Approval of reserved matters following outline consent WA/26/18/OUT for layout & scale for 6 No. dwellings & 6 No. detached garages.

Lanes End West Walberton Lane Walberton

Thank you for your internet representation made on 13th March 2019 which has been recorded as '**an objection**' with the comments as follows:

PLOTS 1 AND 2 FLOOR PLANS AND ELEVATIONS

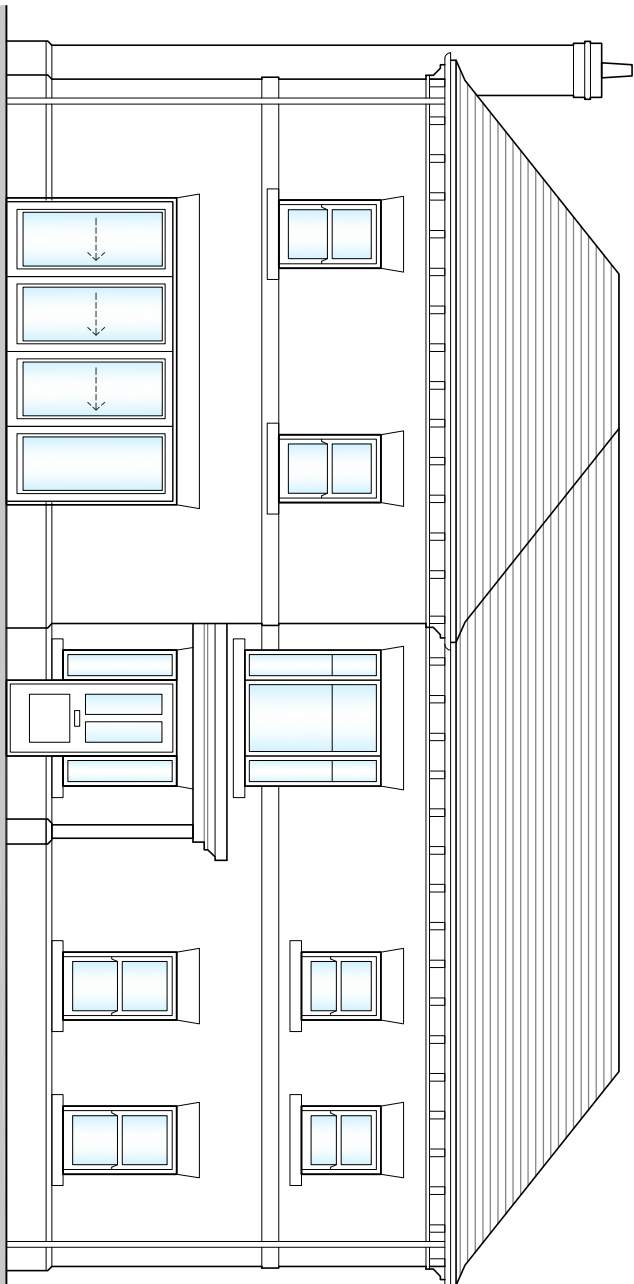
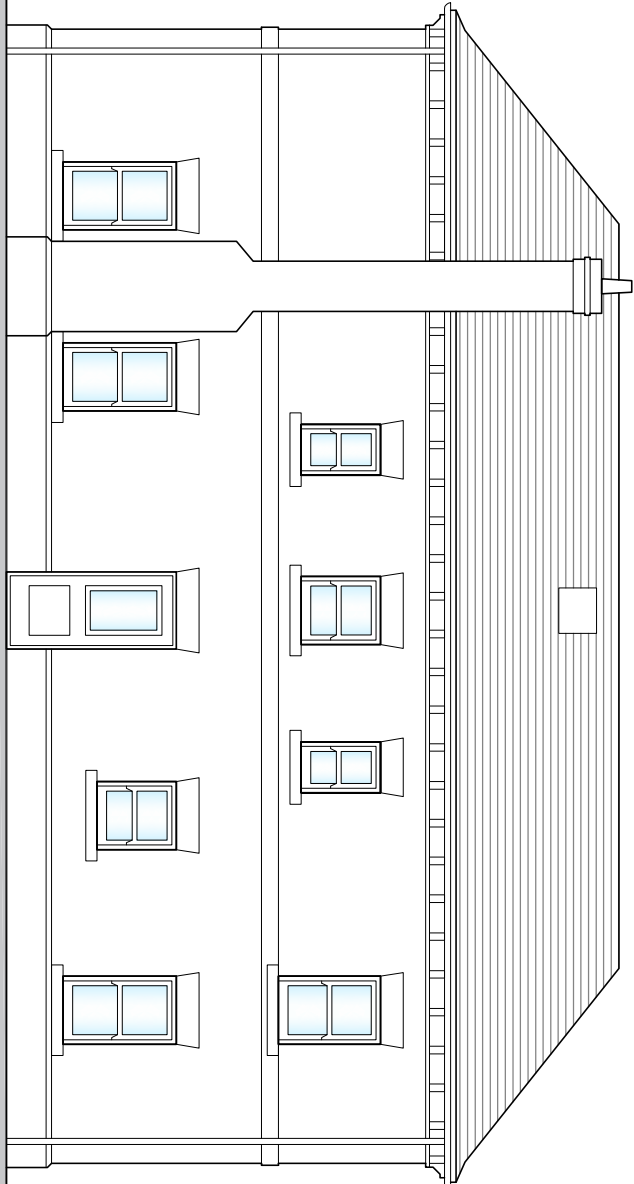
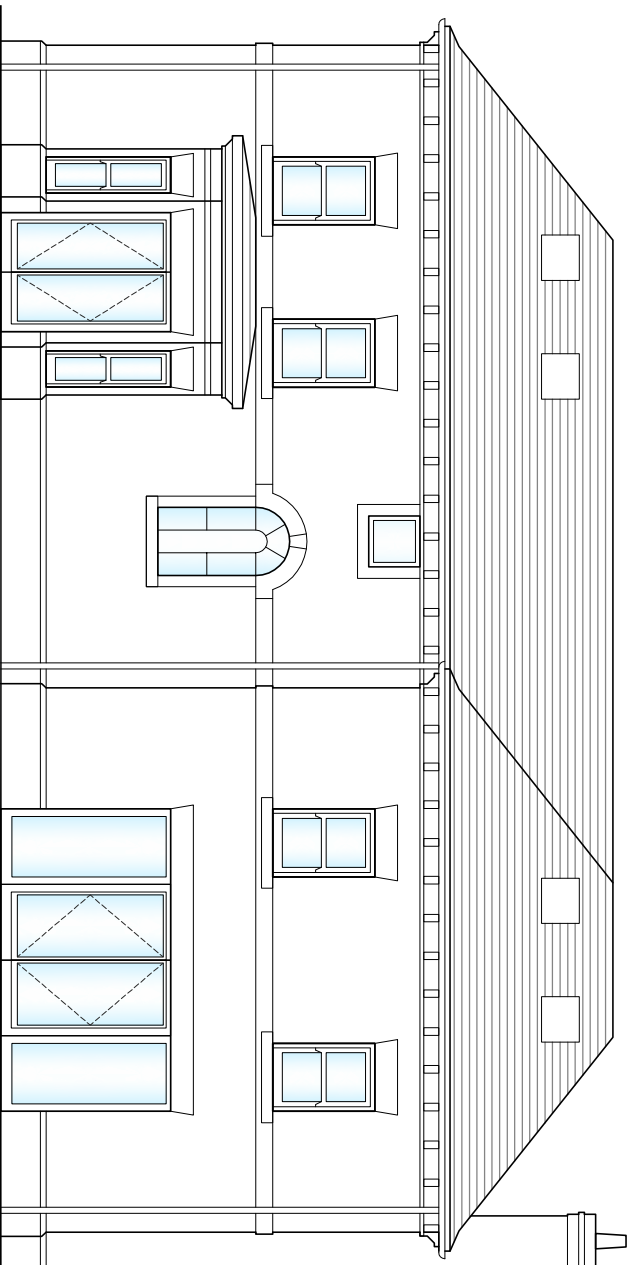
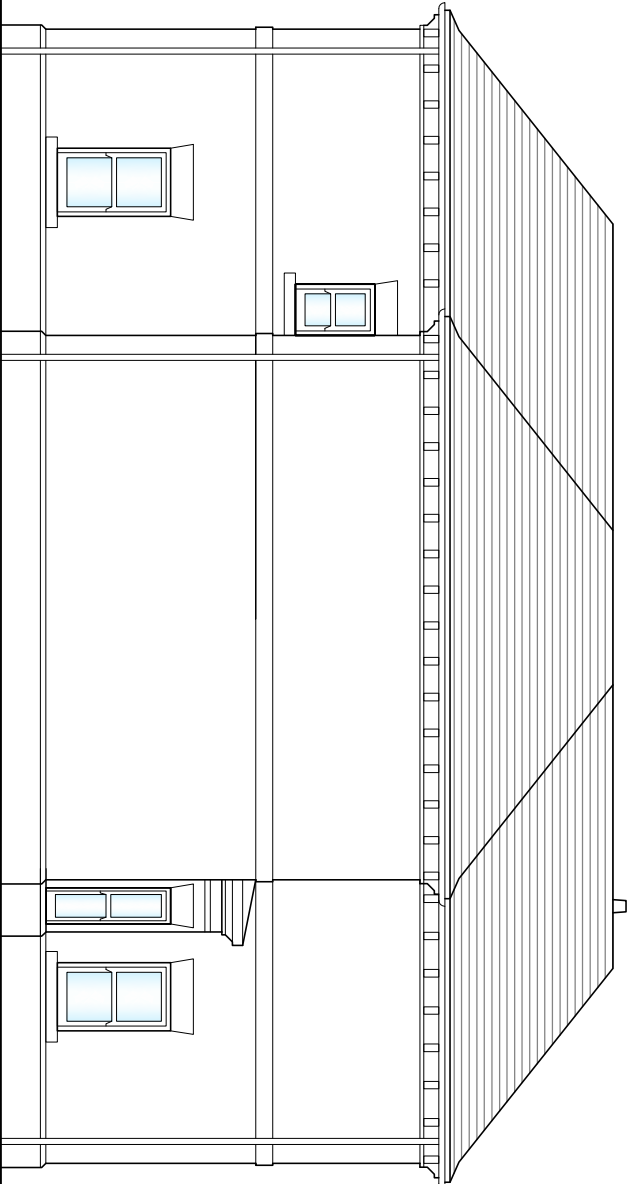
Having considered this application i have great concern over the 3 storey proposal of these dwellings as this is totally out of character to the area and will set a precedent for tall building and flats that don't belong in this area. The 3rd story dormers should be removed as this will affect neighbours privacy. Removing of the trees is a conservation concern as well as the increased hard surface area that could cause drainage issues.

This application is totally out of character for the area and should be reconsidered for a smaller scale development with 2 storey dwellings.
